Summary of Comments on P:\100\100.064\prelim plan \early grading\100.064early grading cover sheet C0.1 (1)

Summary of Comments on Microsoft Word - 100.064-pdr

OUTLET STRUCTURE DETAIL - SECTION B-B
NO SCALE

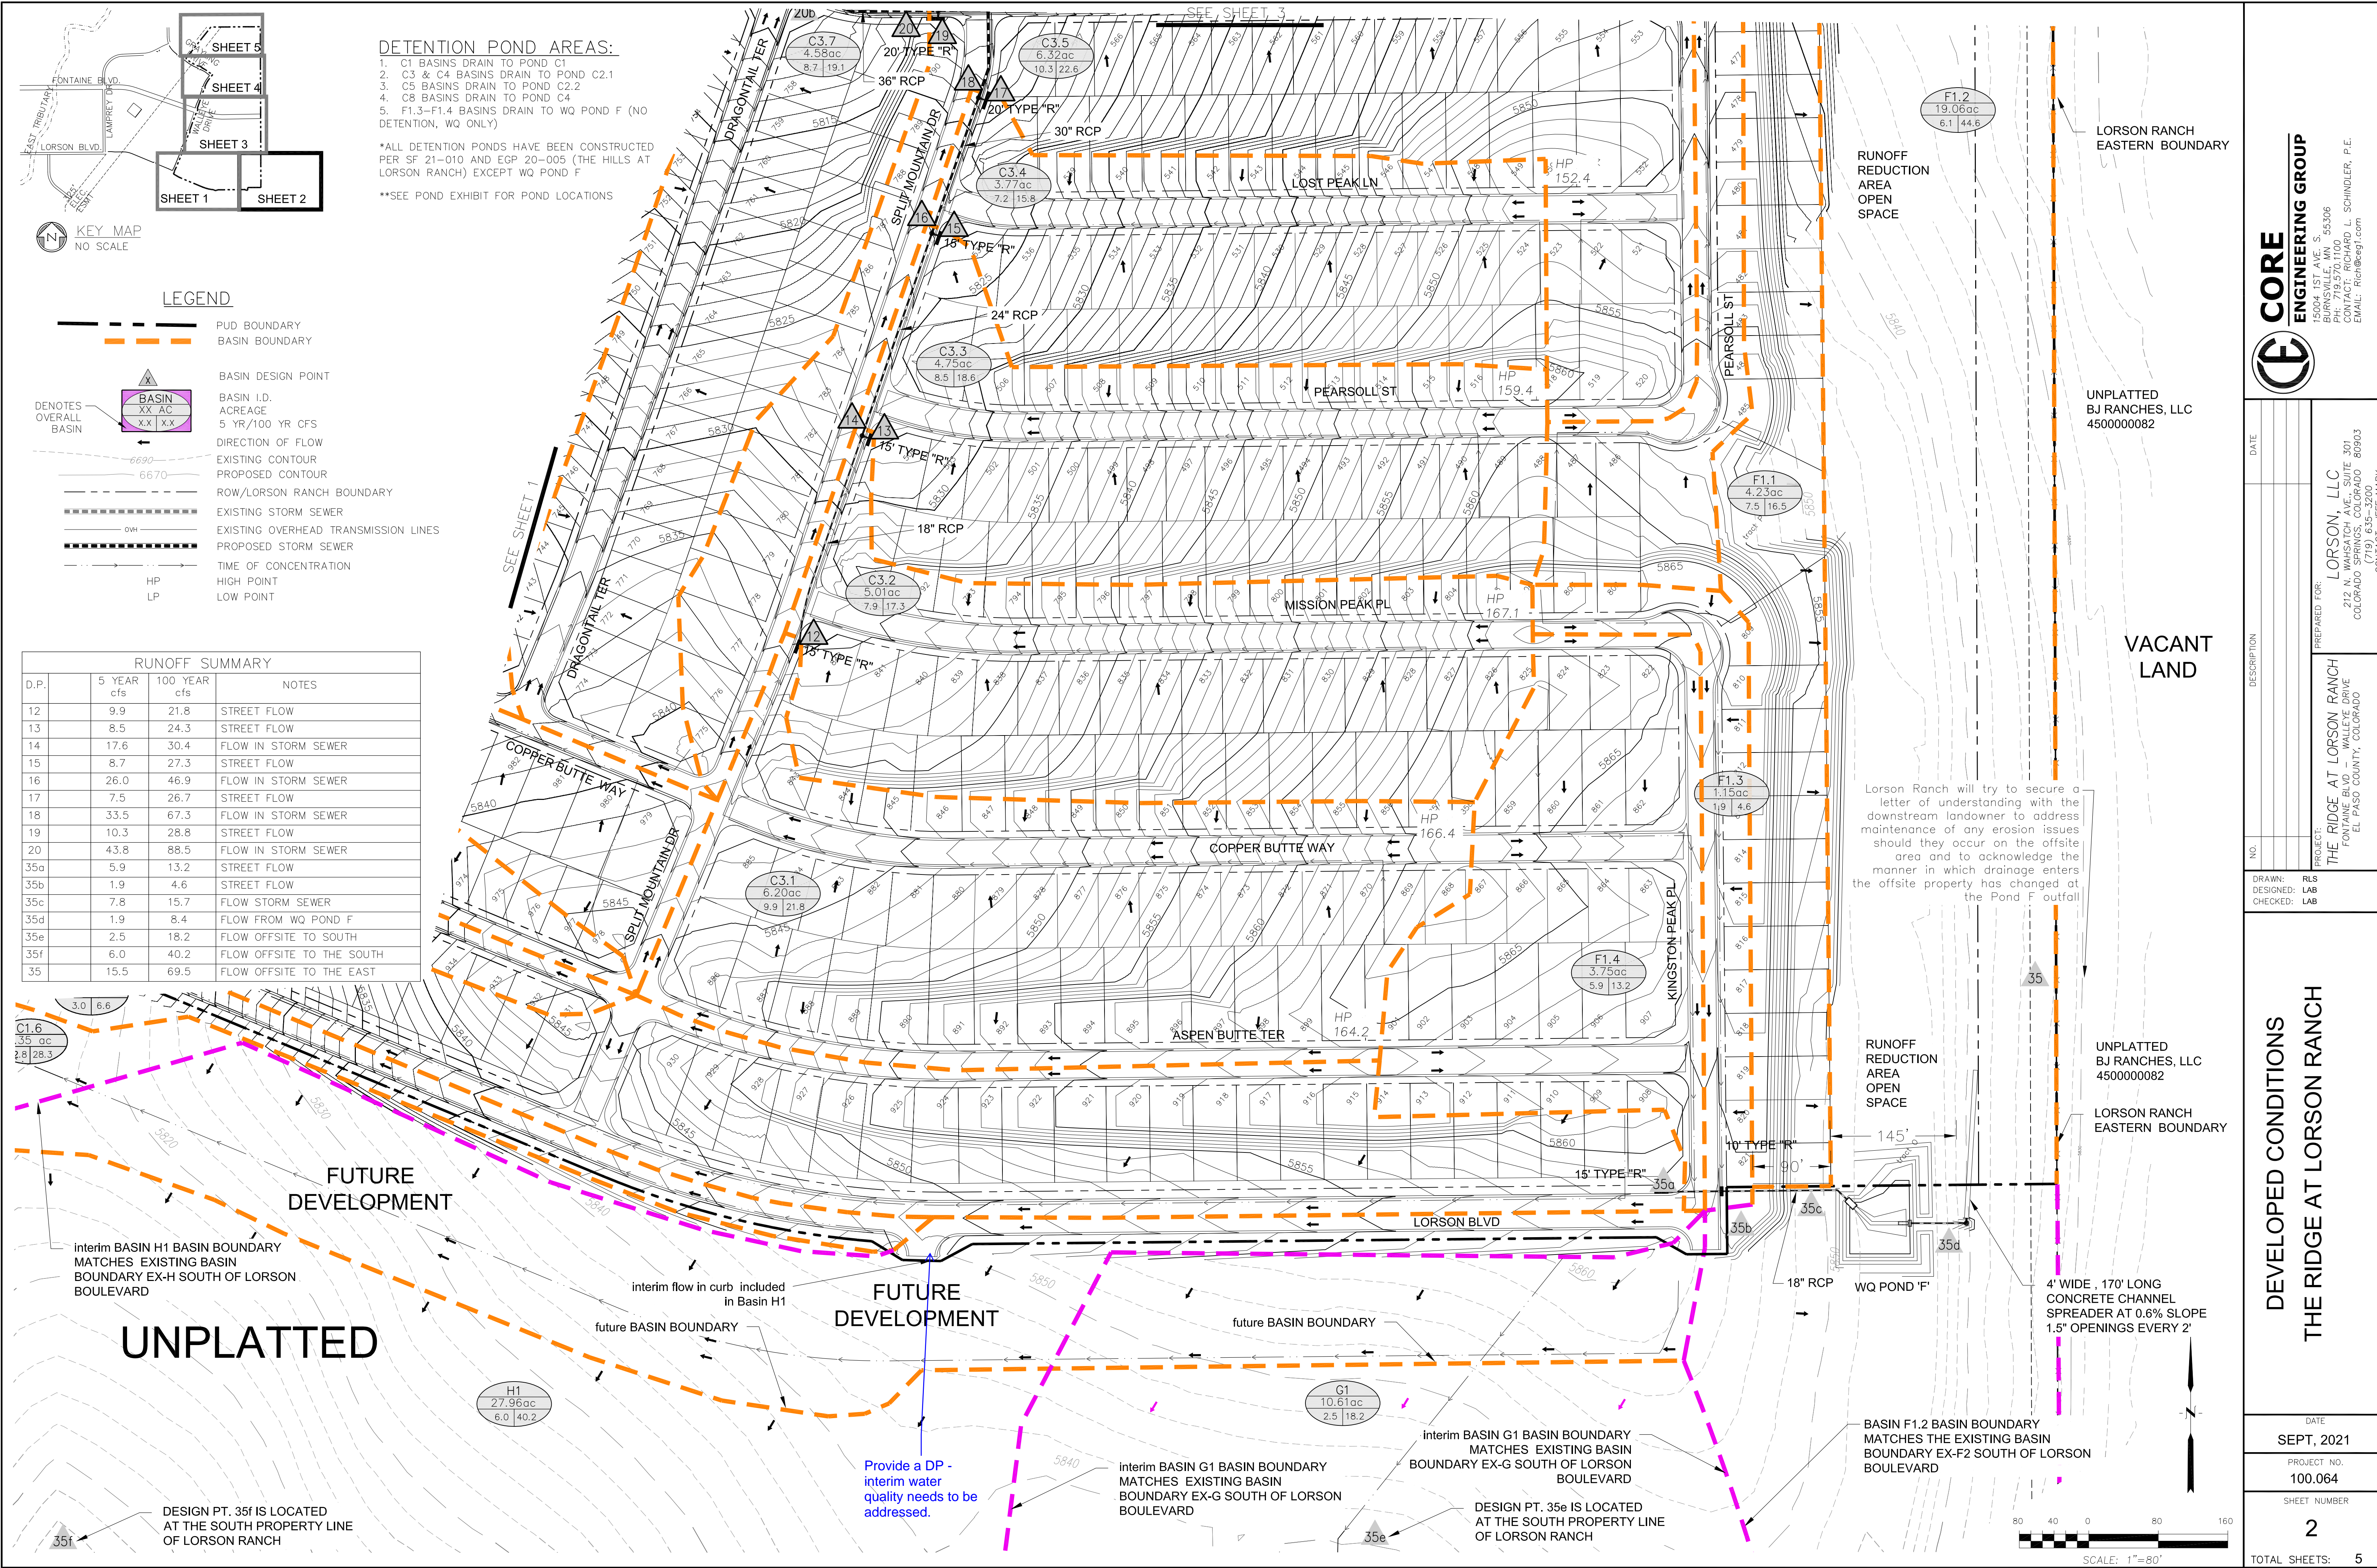
Author: EPC Stormwater - Glenn Reese Subject: Contractor Date: 11/4/2021 1:40:48 PM -05'00'
Consider using soil riprap for the overflow per detail in Chapter 12 of MHFD USDCMv2, pg 12-33 as well as placing ECB.

Author: dsdrice Subject: Callout Date: 11/4/2021 1:35:52 PM -05'00'
A cutoff wall is recommended to prevent spillway failure.

Author: RSchindler Subject: Sticky Note Date: 11/6/2021 8:39:45 AM -05'00'
added TRM. pond is entirely in cut and overflow is at existing grade.

Author: RSchindler Subject: Sticky Note Date: 11/6/2021 8:40:42 AM -05'00'
added TRM. entire 100year flow enters the outlet structure. pond is entirely in cut so the overflow/slopes are below existing grade and cannot fail.
